Your Ref: OWPC23262
Our Ref: P/38/19/PL 09-04-2019
Please ask for:
Mr S Davis

Year round retention of seasonal workers accommodation.
Newlands Nursery Pagham Road Bognor Regis

Access to Main Road
PROPOSED
May 2019
0119-003
1:500@A3

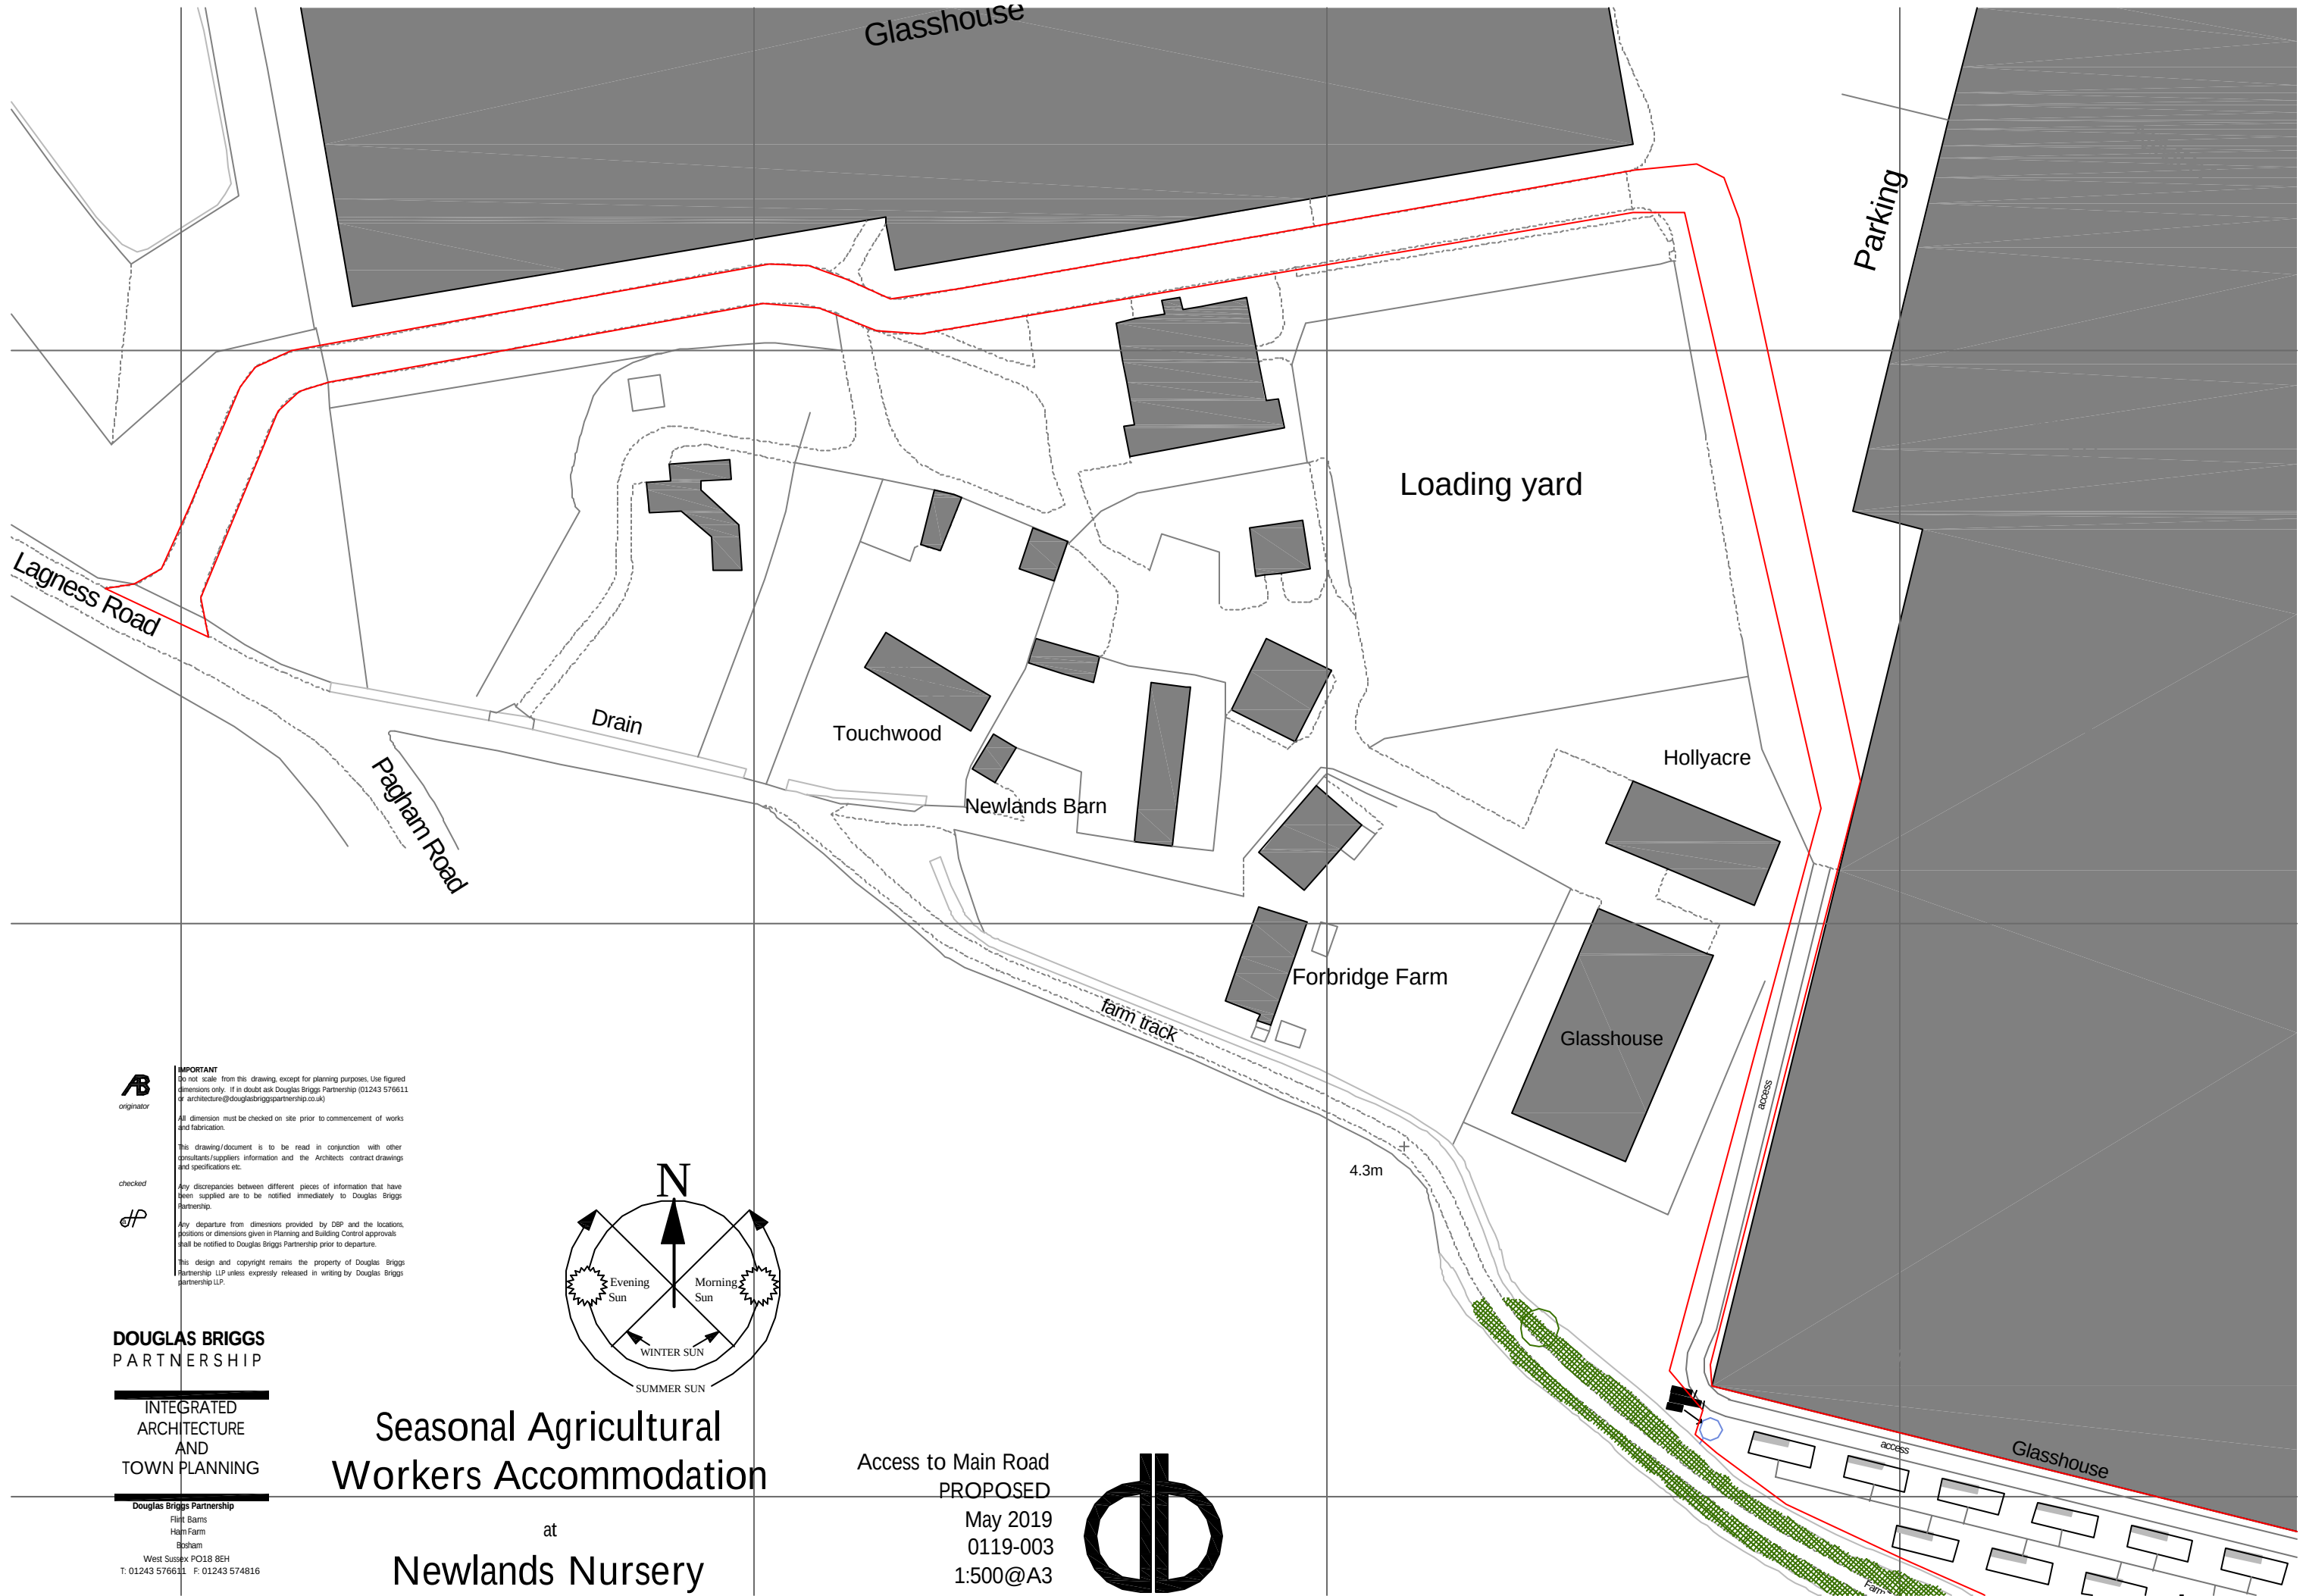
This site is not suitable for caravan occupation. Its entrance is on a dangerous bend where numerous accidents occur. There is no pedestrian access to the bus stop which is half a mile away. It is not safe for cyclists on this road which are not only a severe hazard to vehicles particularly the artics going in and out of Barfoots and motorists causing long tail backs as they cannot be overtaken.
